DATE	11/02/2022	JOB	2808	PAGES	1 of 2
PROJECT	SSD-10371 - Trinity Grammar School The Renewal Project SSD				
TO	Peter Brogan				
COMPANY	Bloompark Pact				
FROM	PMDL				
REFERENCE	Architectural Response to Submission for Modification

Architectural Modifications

The proposed modifications to SSD-10371 are summarised as below;

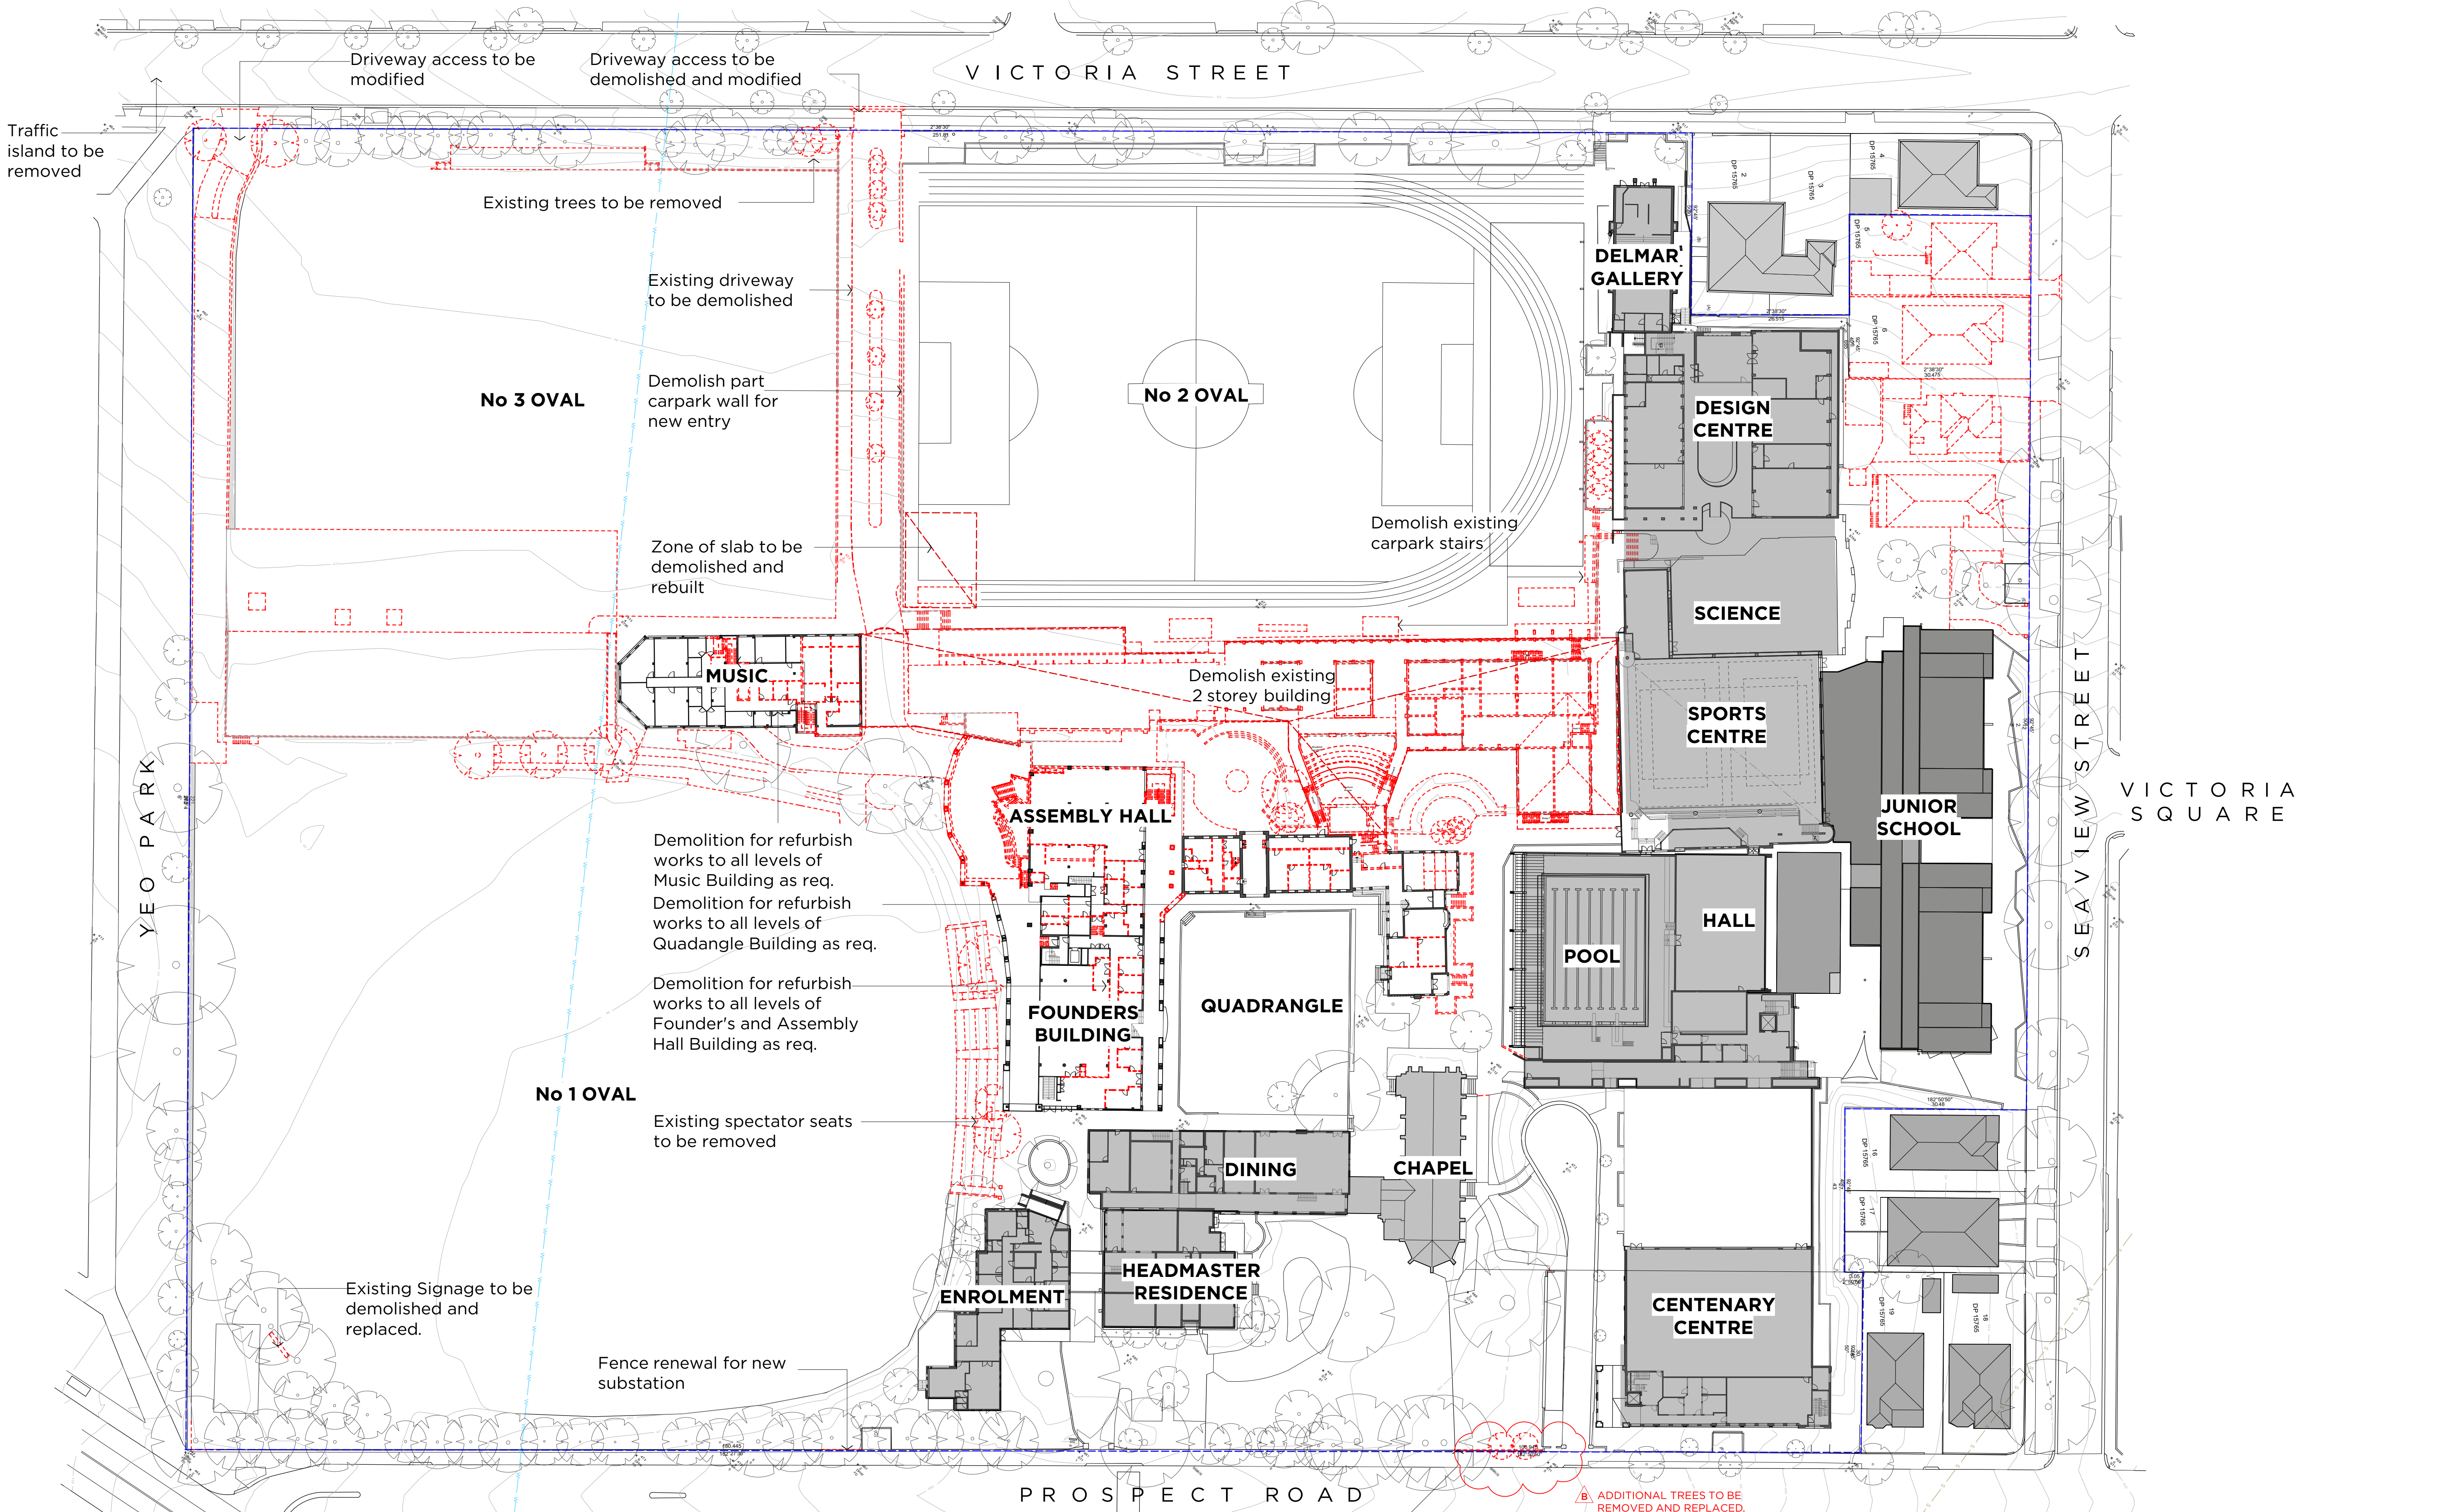
- Removal and replacement required for 2 trees at the Prospect Road Chapel Drive entry through the design development process. (refer to Arcadia's design statement for more details)

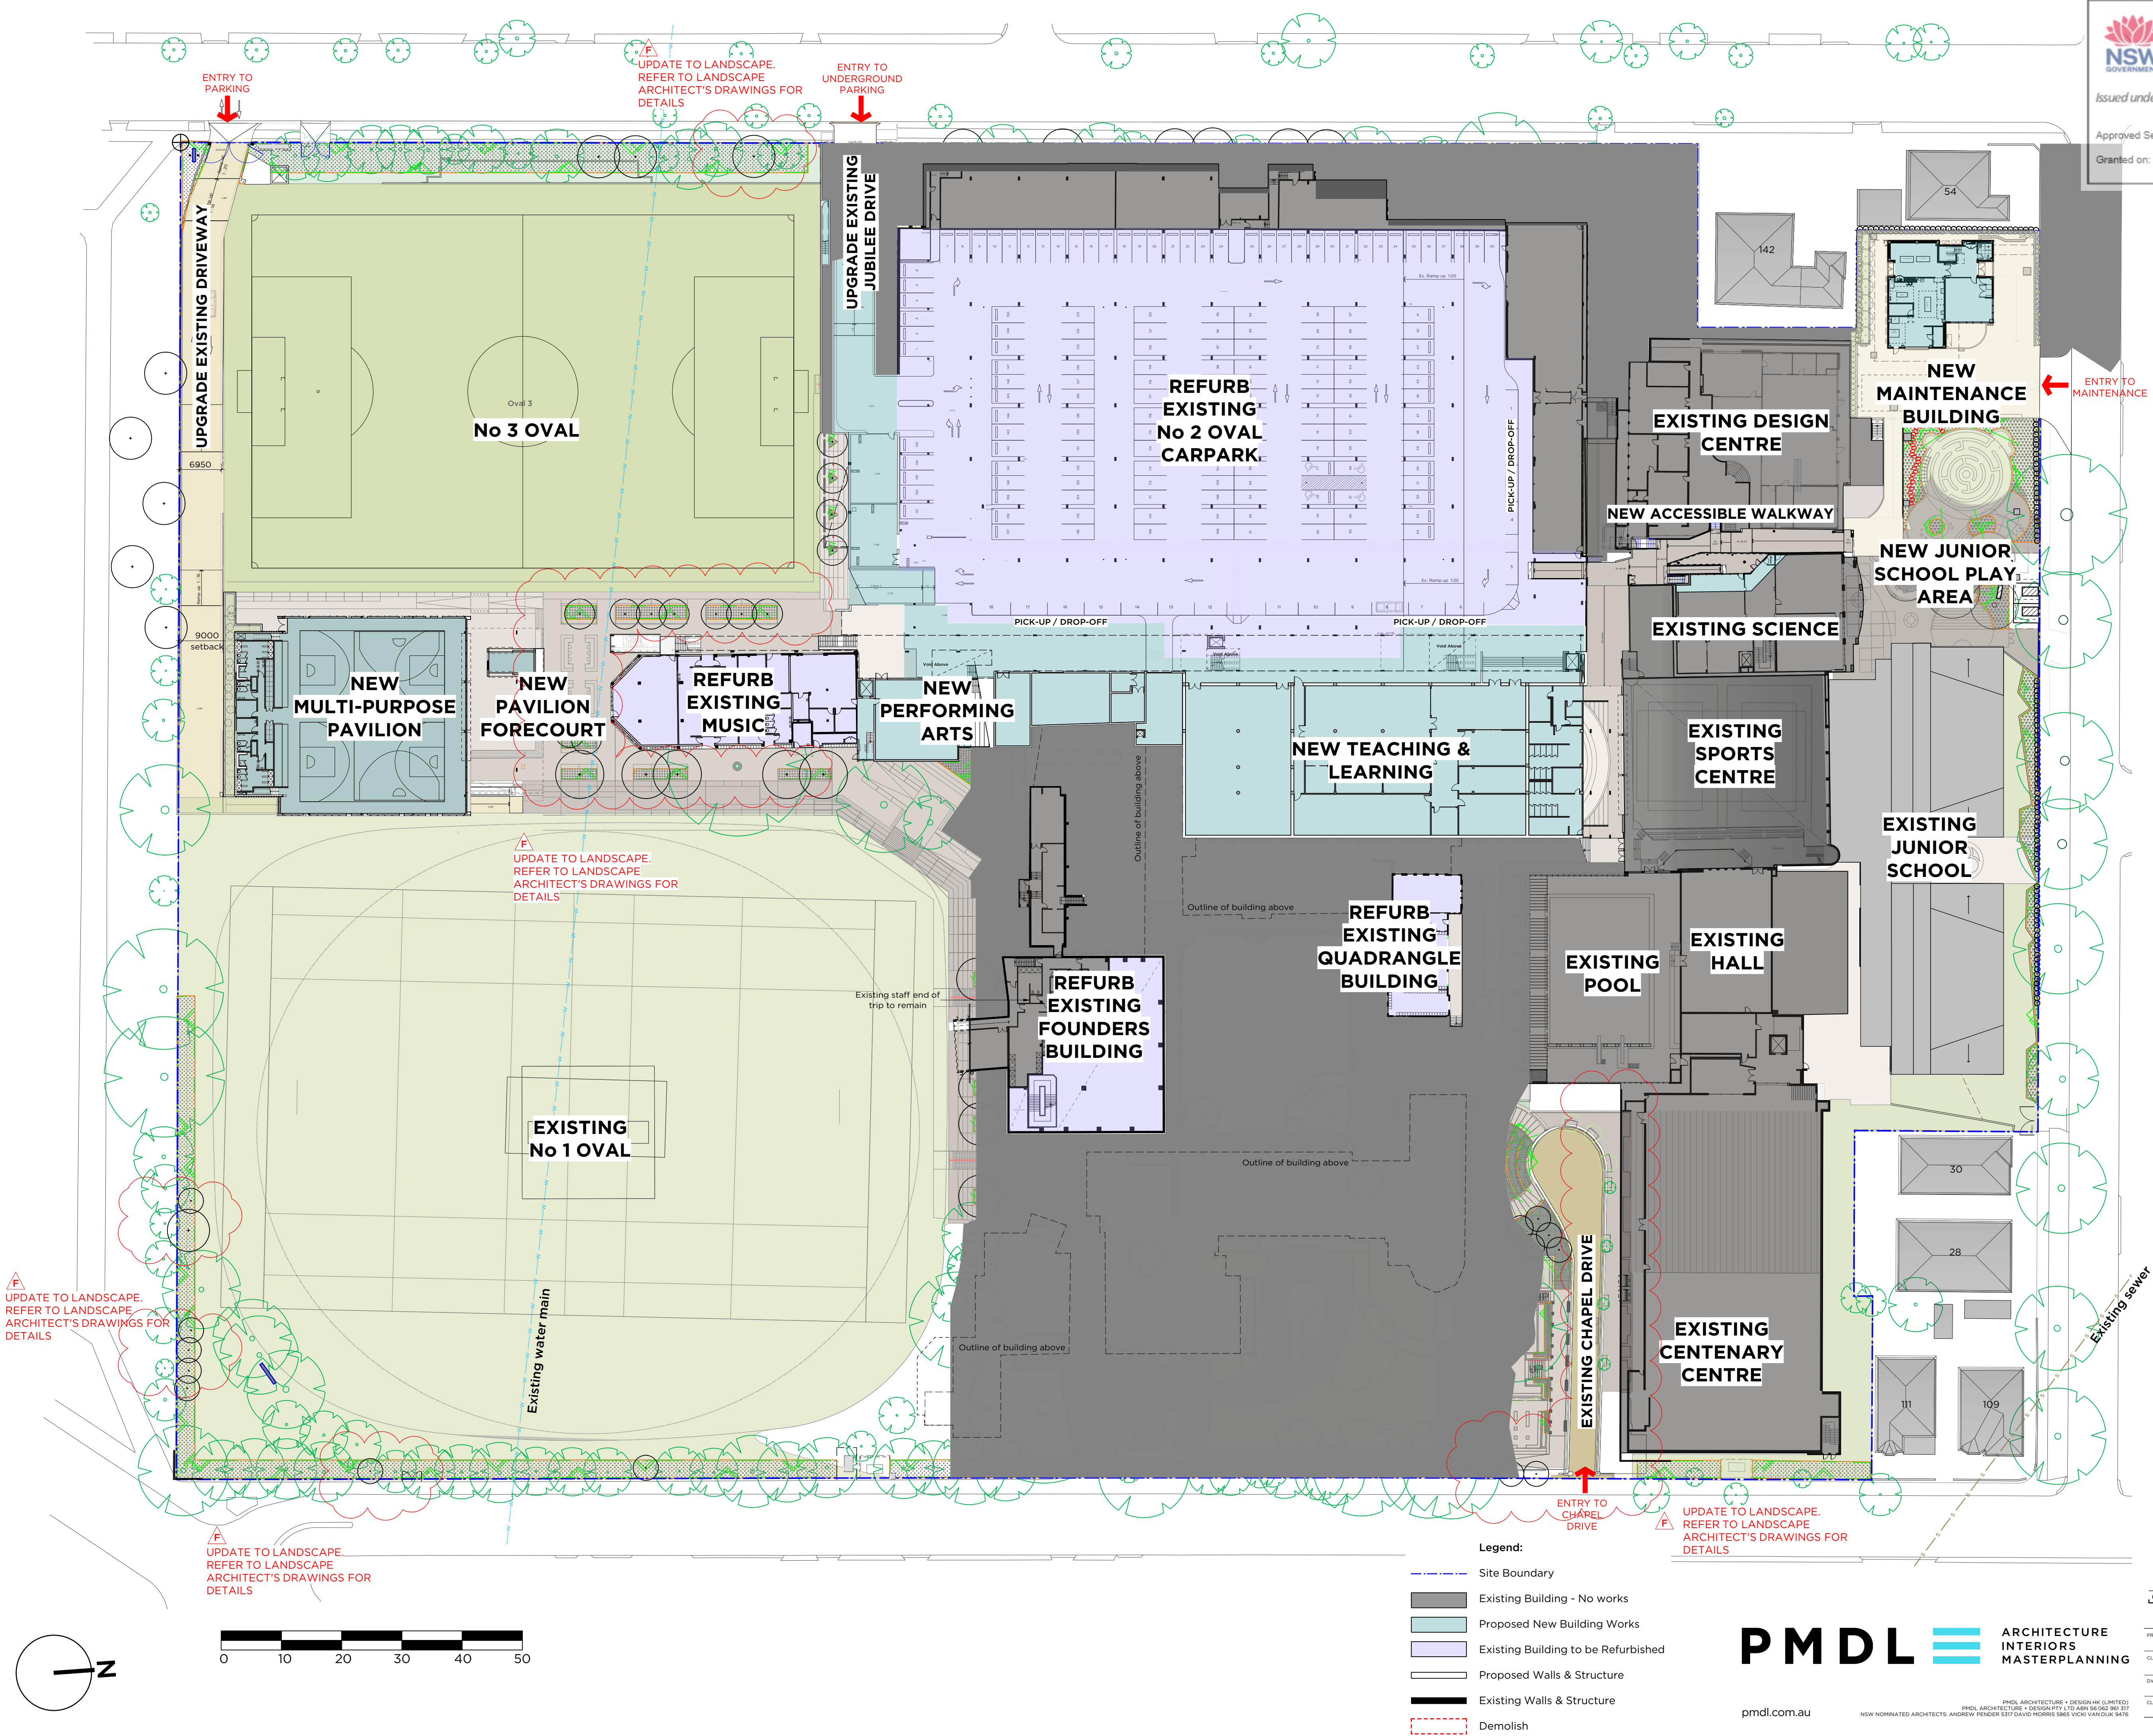
- Landscape design changes following design development and project coordination.

01 PLAN
DA131 Level B1 Proposed
Scale 1:200

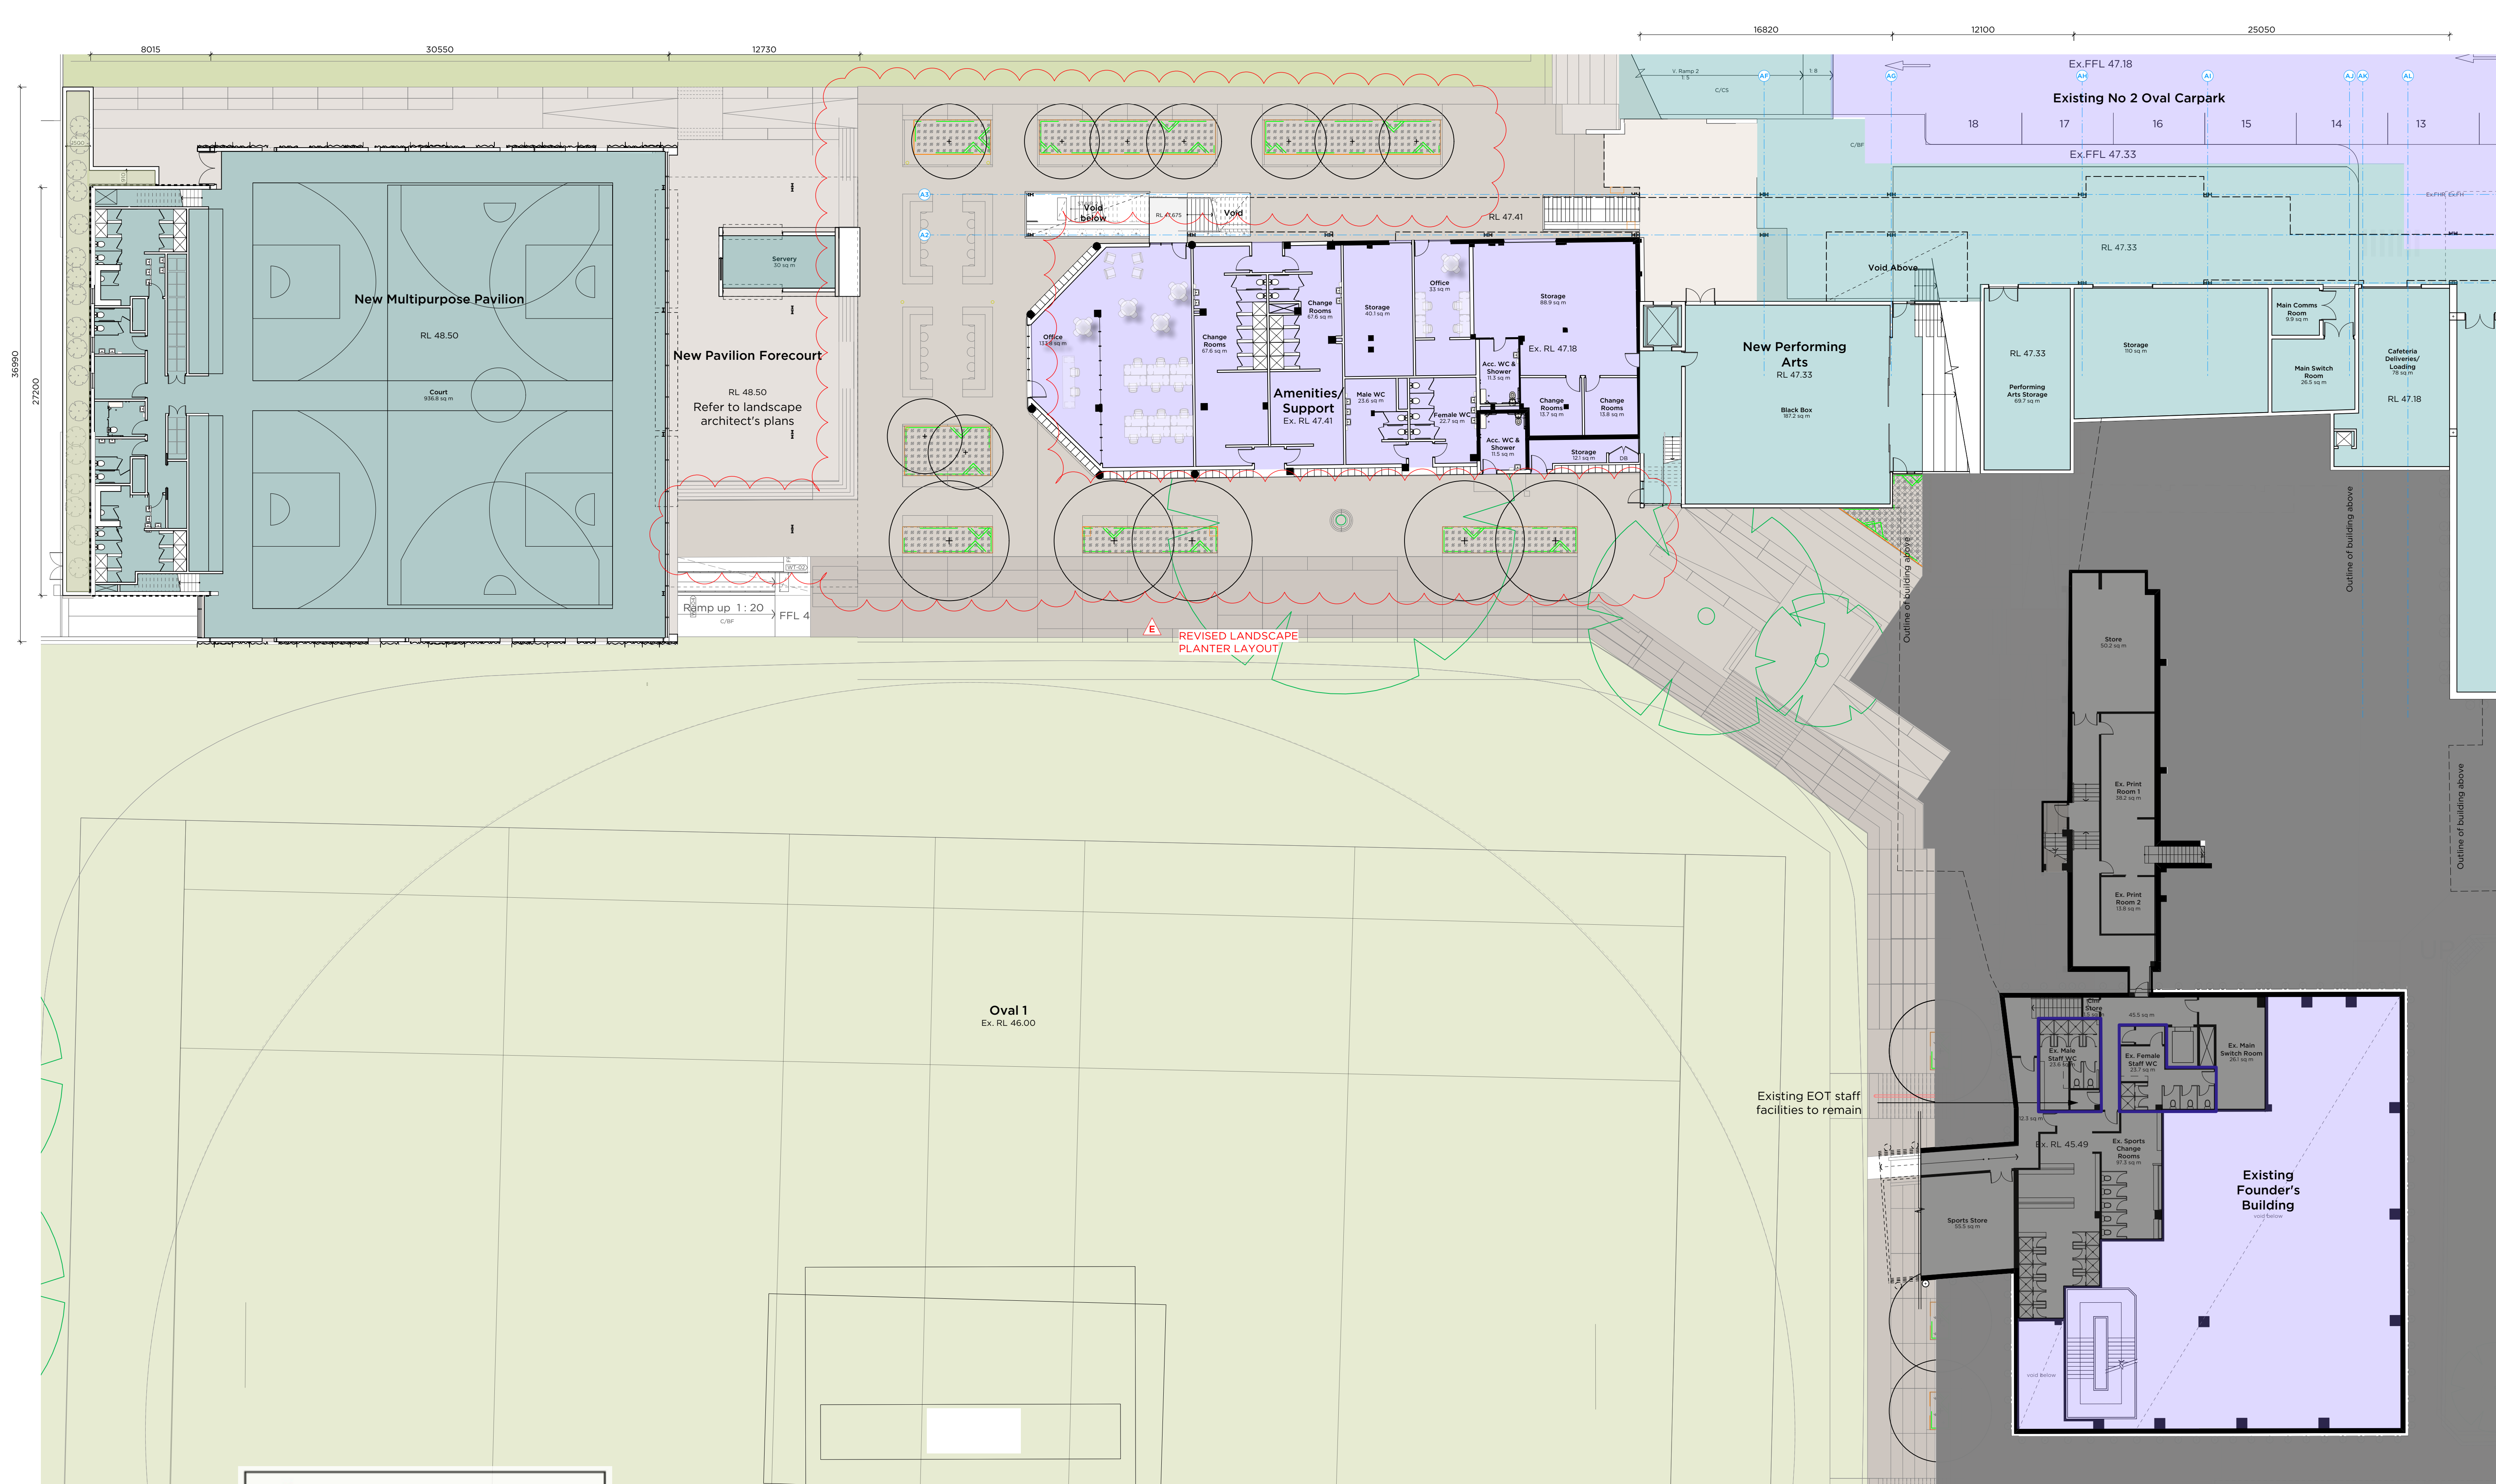
- Landscape Planter design changes following design development and project coordination.
